# CITY OF ALBUQUERQUE

**Re: 716 Roma Residential Condominiums, 716 Roma NW,  
(J-14/D153)**

**Approval of Permanent Certificate of Occupancy  
Certification dated 12-6-07**

**SHEET NO. C-1**

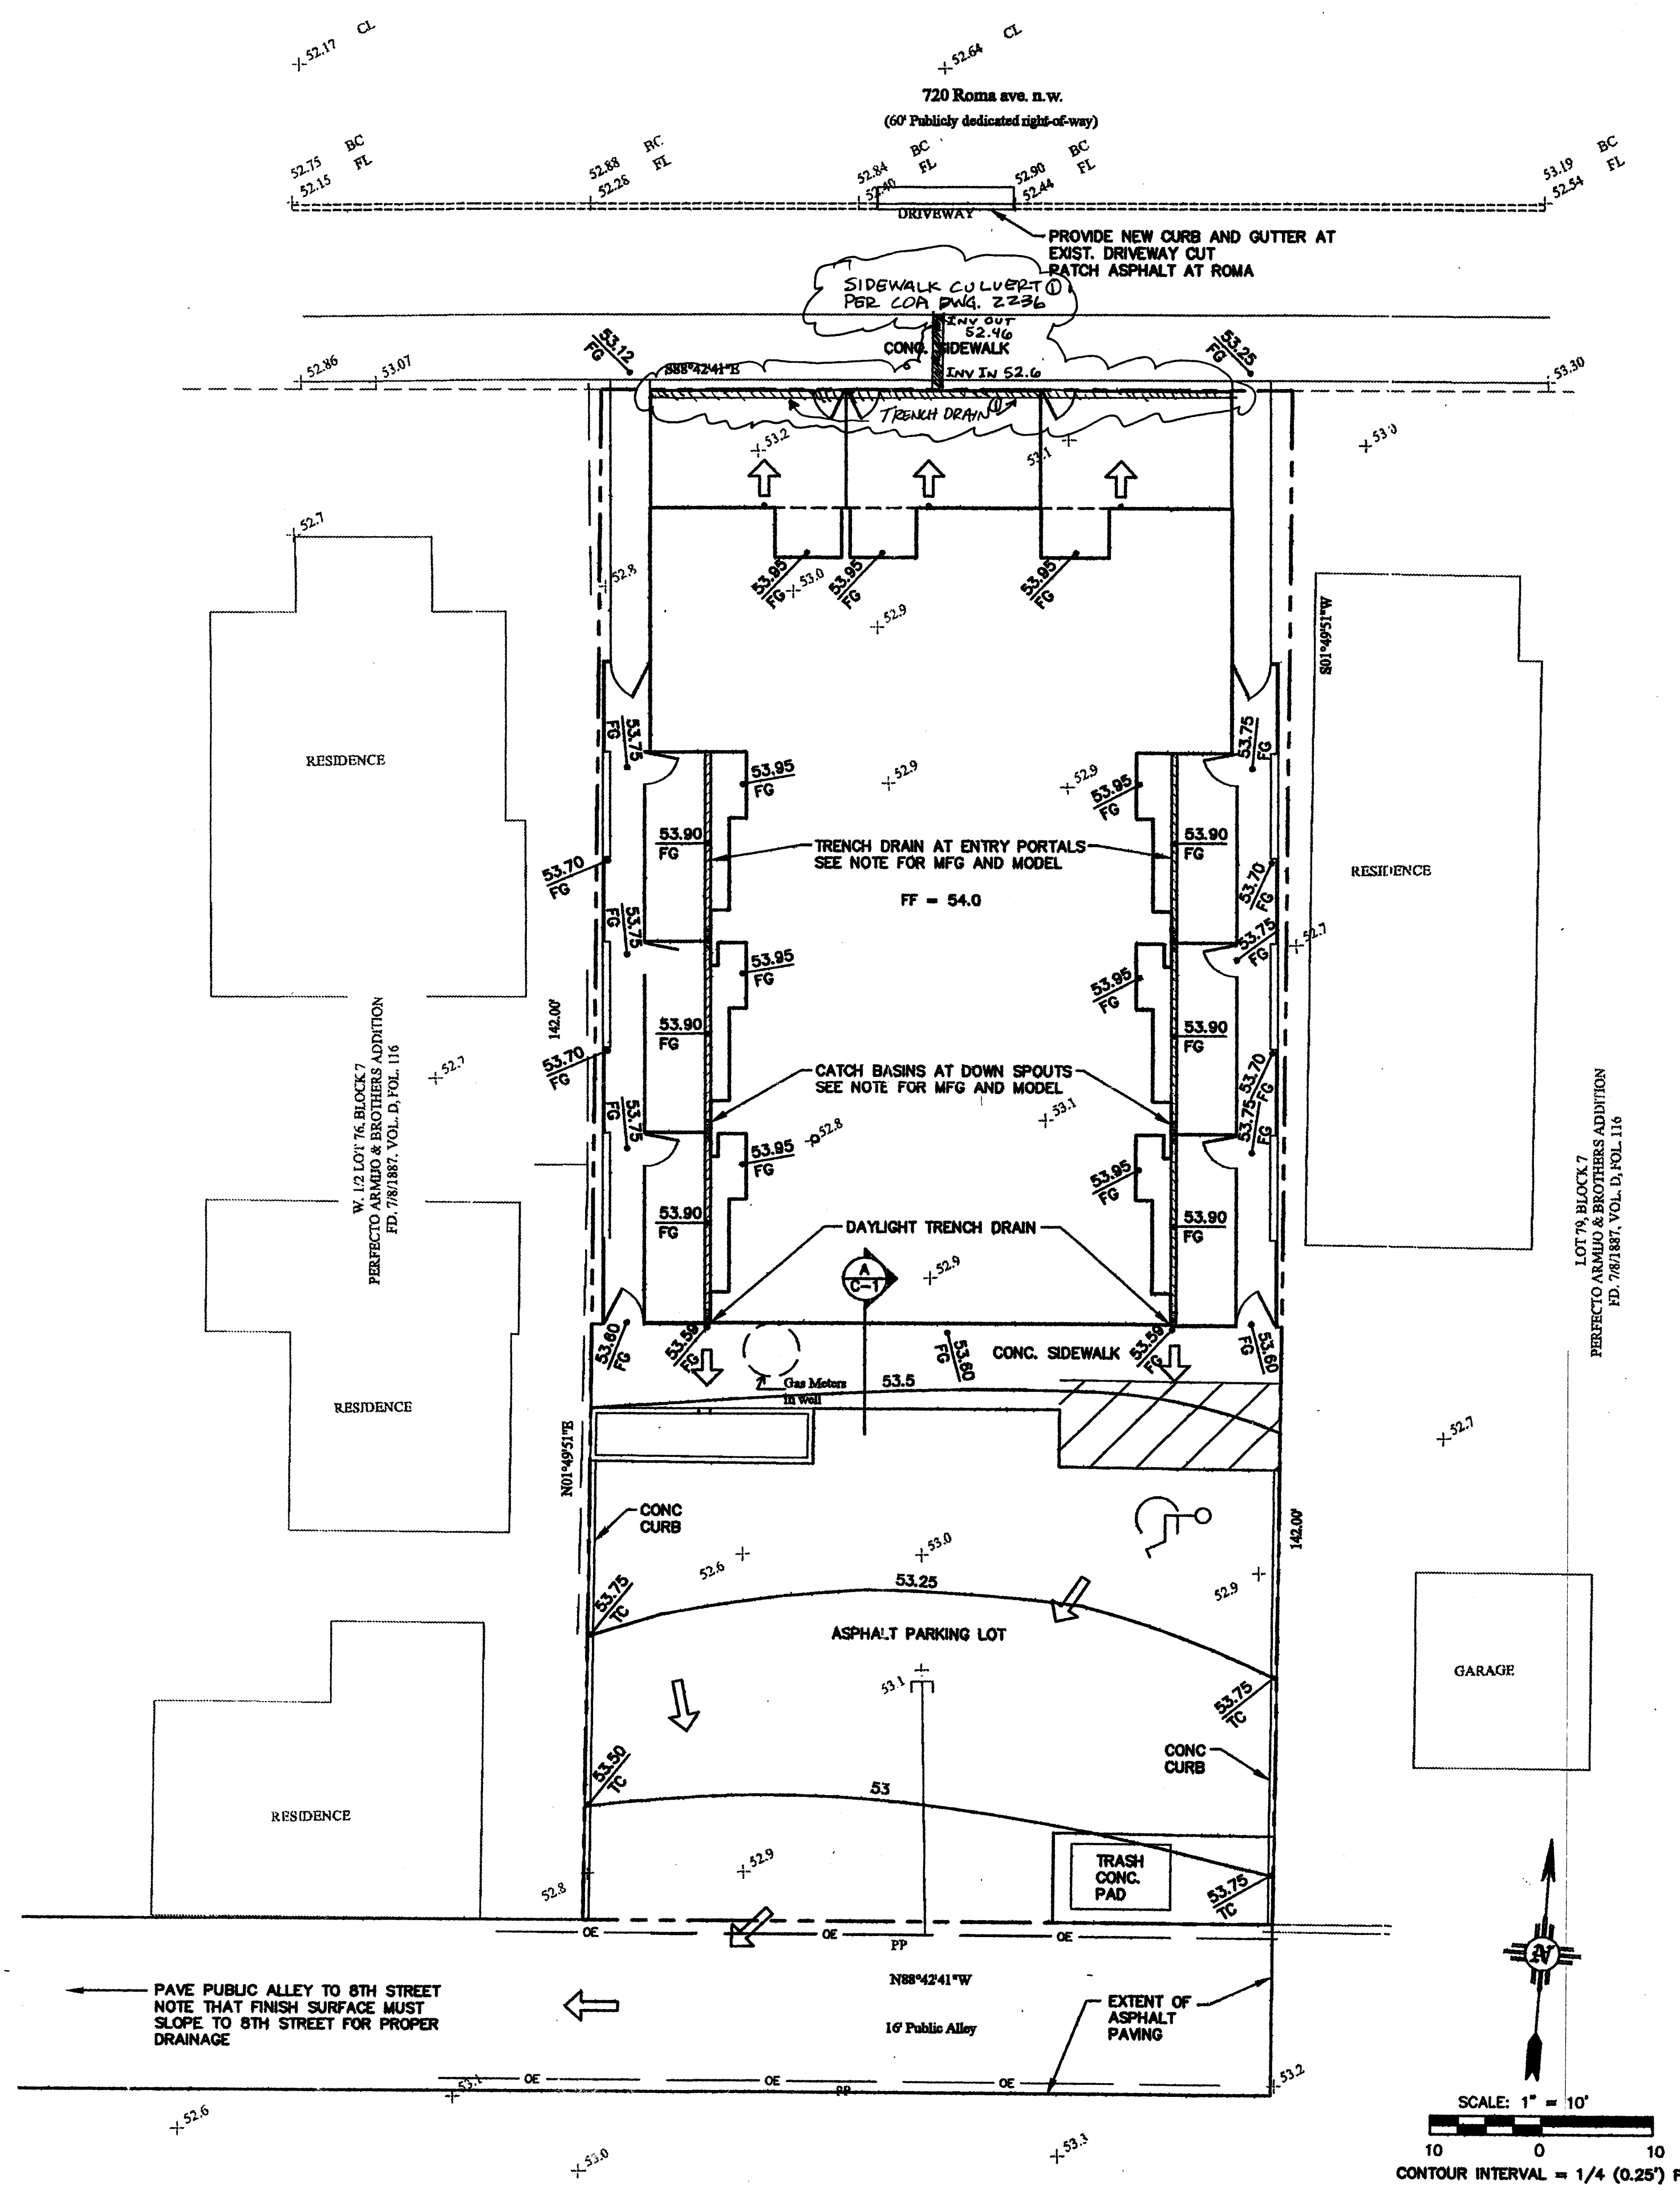
- The SO #19 will need to be inspected and approved by Duane Schmitz @ 235-8016 prior to any Certification of Occupancy.
- Additional elevations are required for the trench drain and sidewalk culvert discharge.
